Regarding: Project PR-2019-002496 at Barstow and Alameda NE
Currently scheduled for hearing on 7/17/2019

I respectfully offer the following comments and requests for consideration by the DRB regarding the Site Plan application for the above identified project.

1 Landscape Plan - East End
1" = 20'-0"

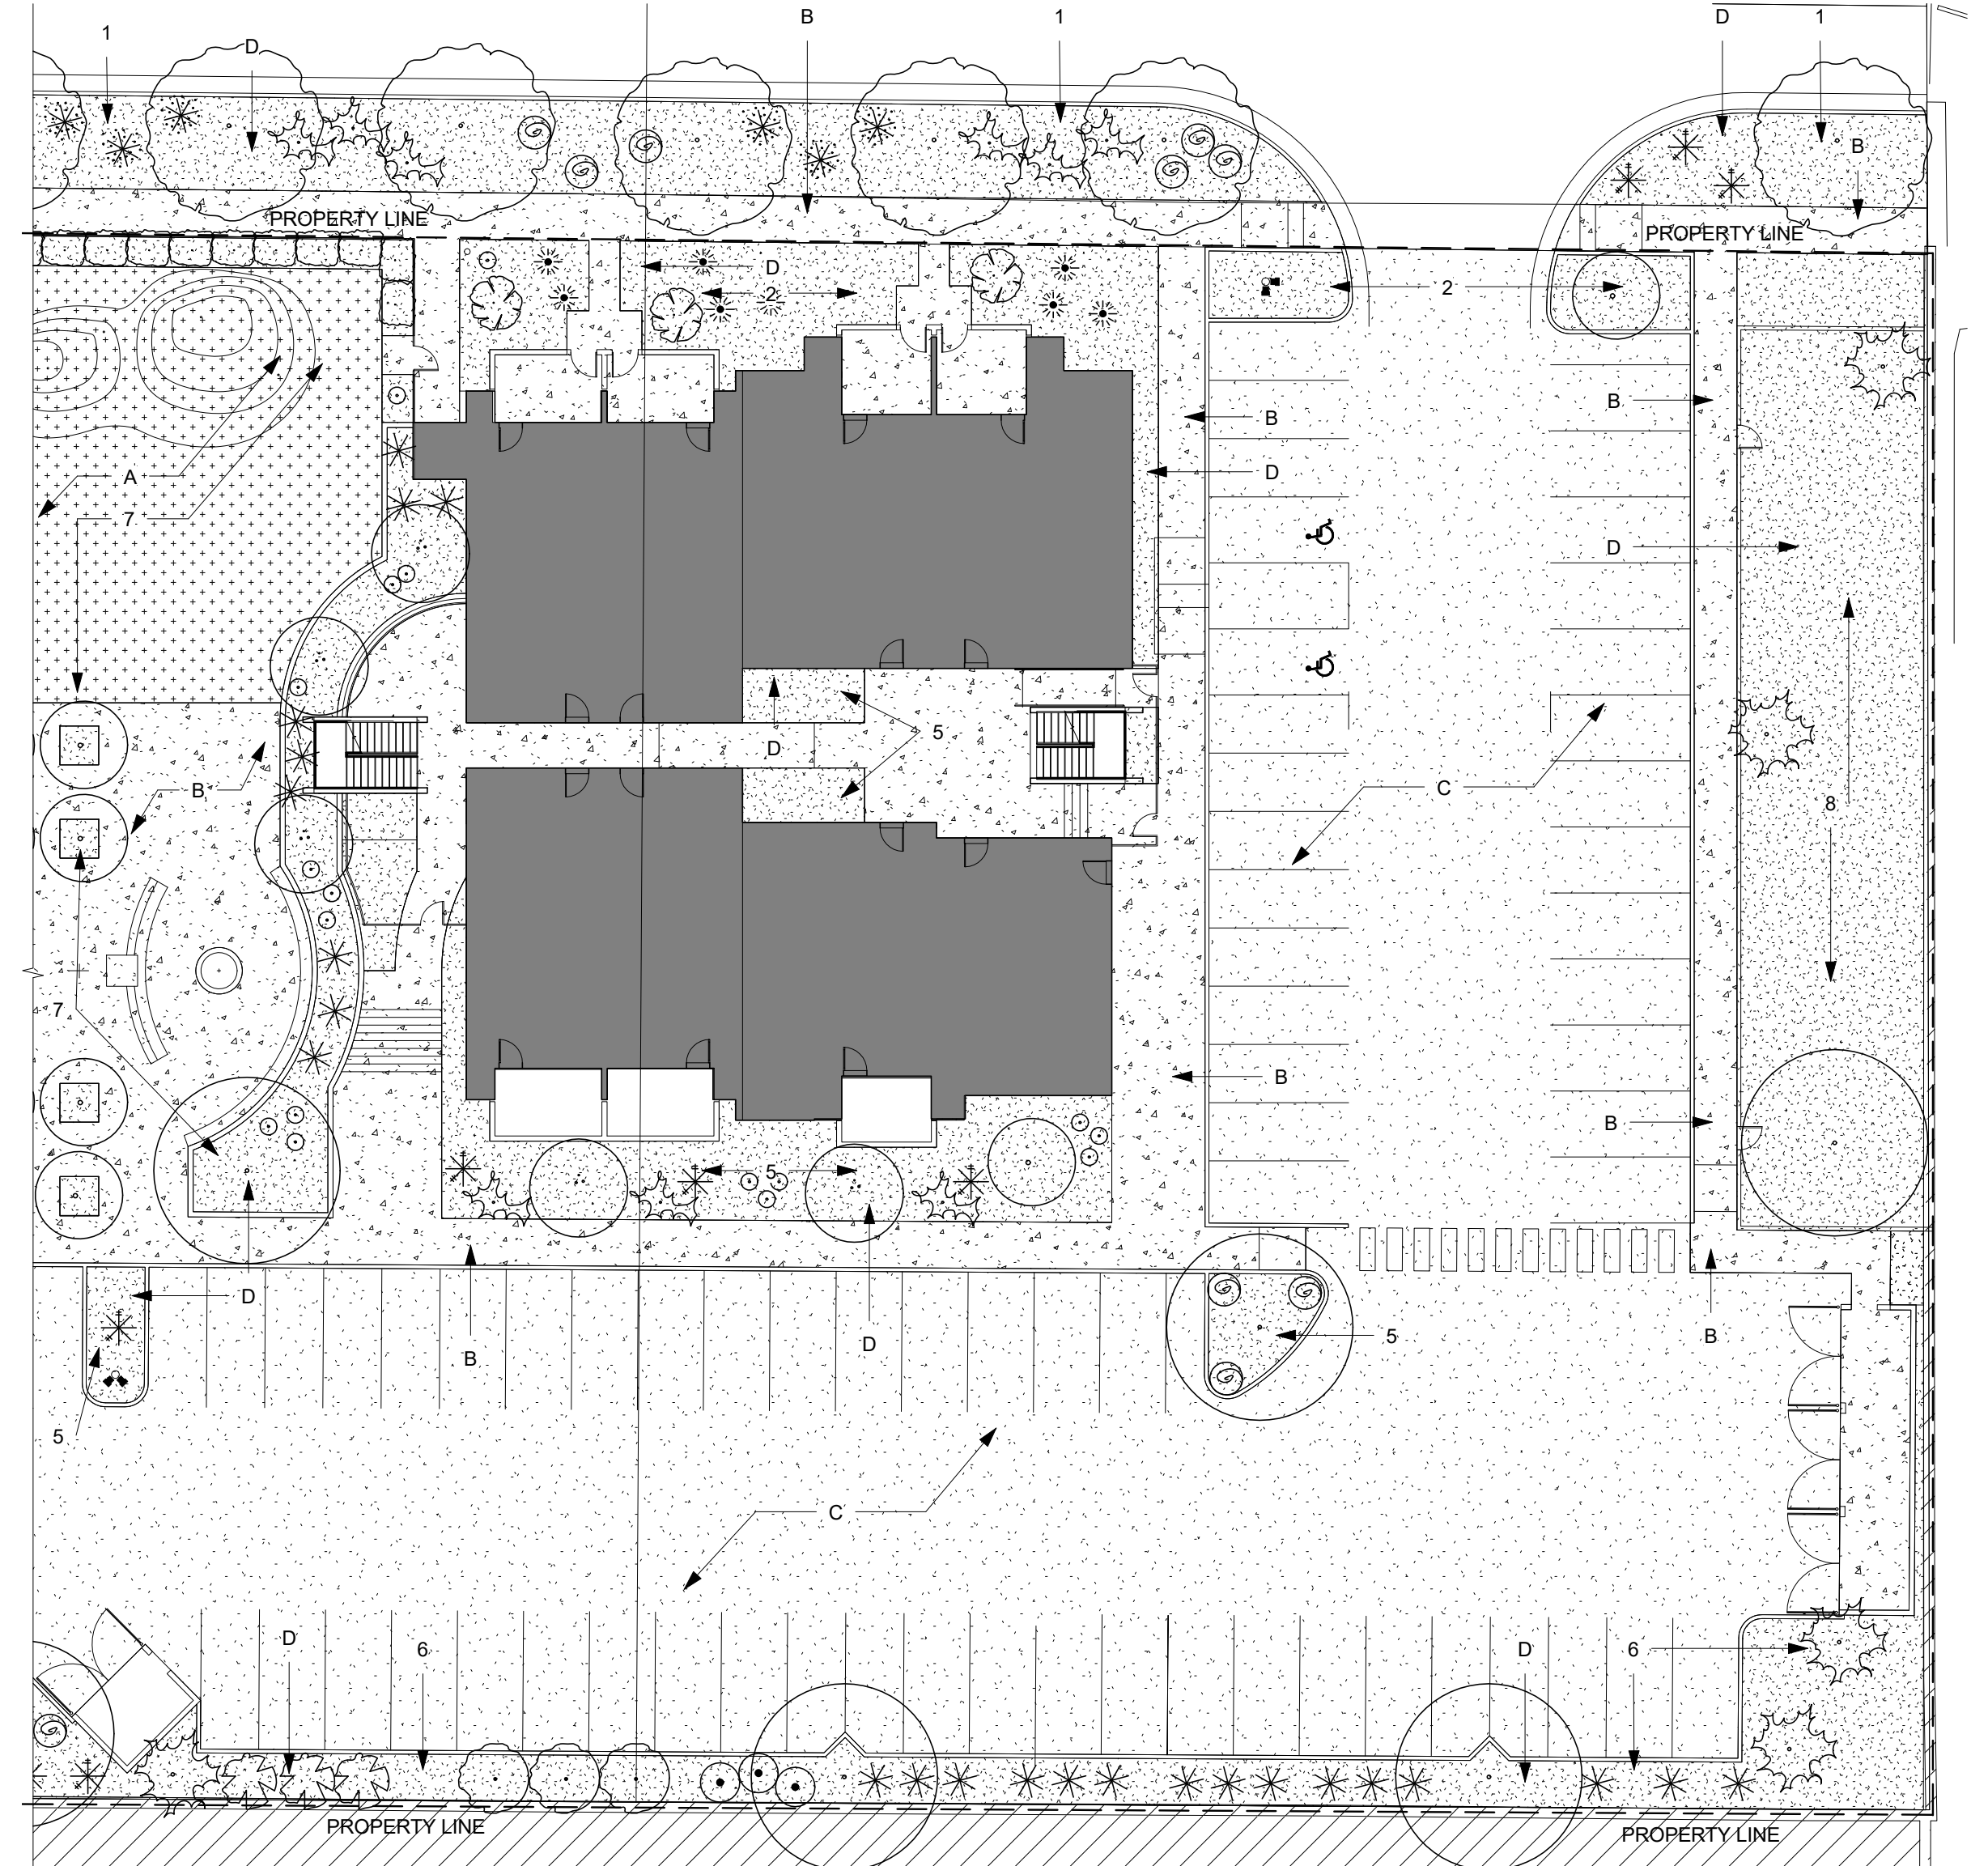
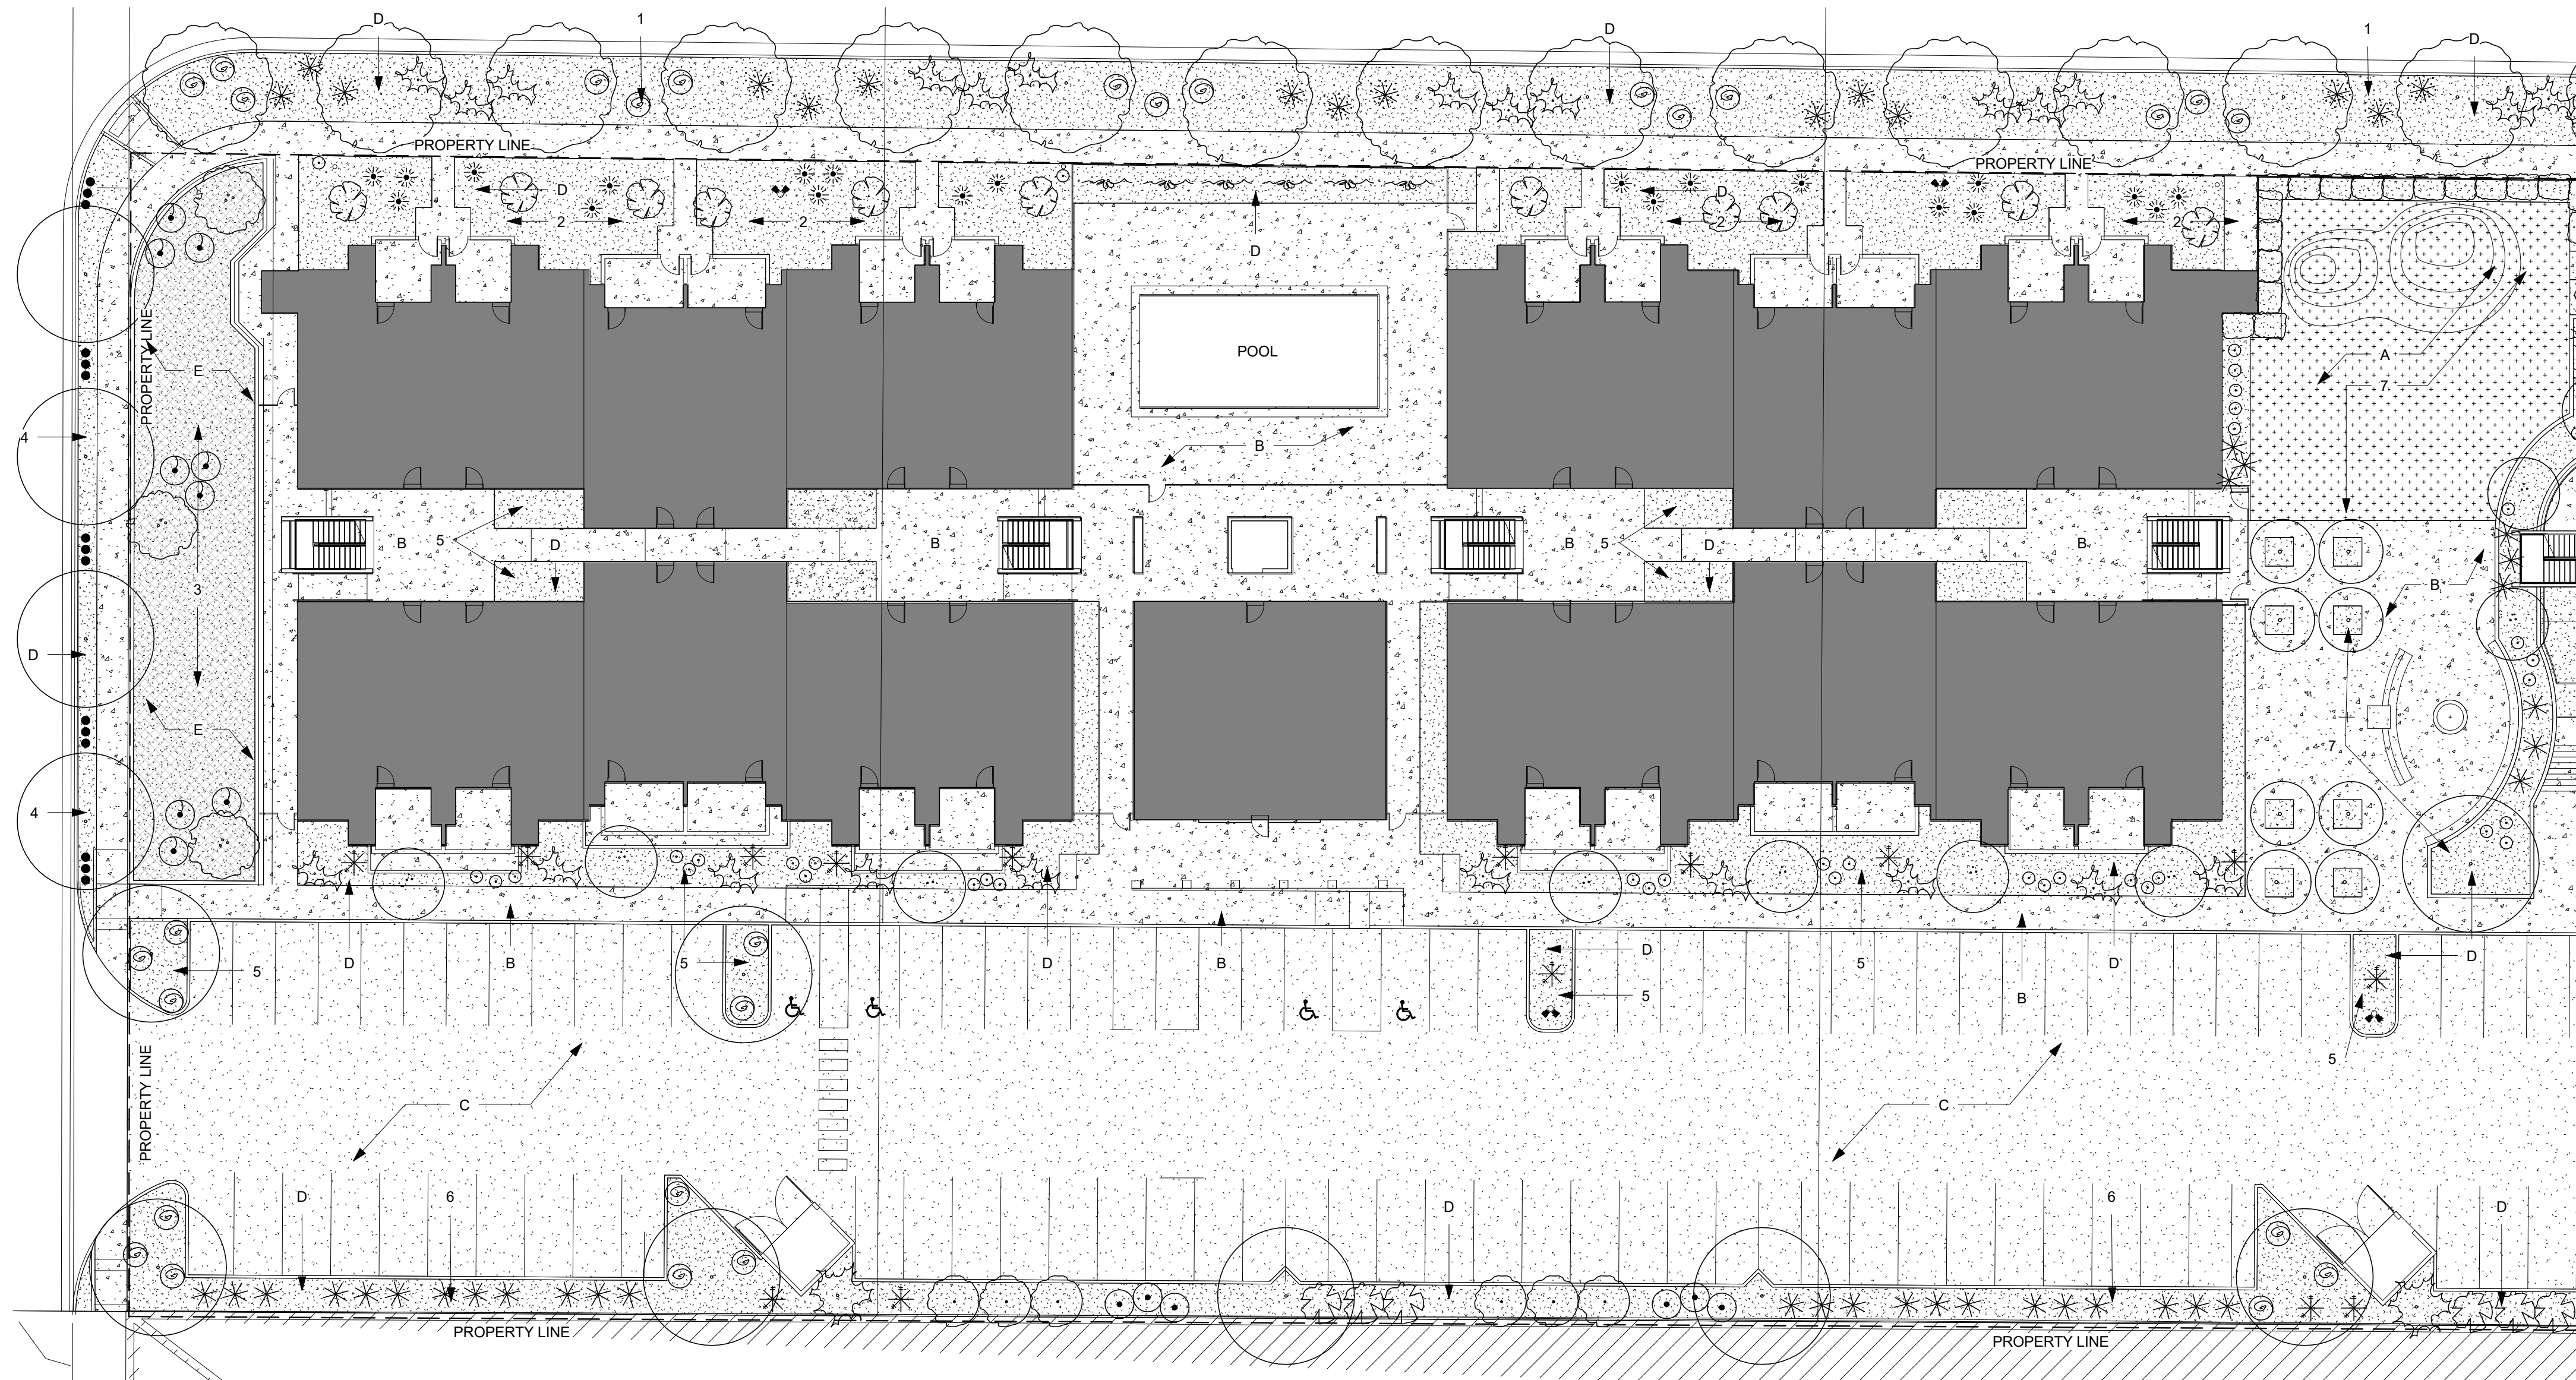
- 3.) 5-6(F)(1)(i) subsection 2 regarding rear parking lot edge landscaping. Once again, in trying to cram too much into too little, this infill project would cause problems. In this case, with only a 6' planting strip against the south property line, trees intended to provide parking lot shade and visual screening are problematic. The visual screening in this case has more to do with screening between the 3 story building and the single family homes than with headlights. As the deciduous trees mature, their canopies will encroach upon the adjacent property owner's primary structures and their root system risk damaging the privacy wall. The adjacent property owner's backyards are on the north side of their property and don't necessarily need or want more shade. This subsection gives the planning director some discretionary authority to approve alternate plans. We recommend city planning, the applicant and the adjacent property owners work together to identify a better solution for shading and screening.
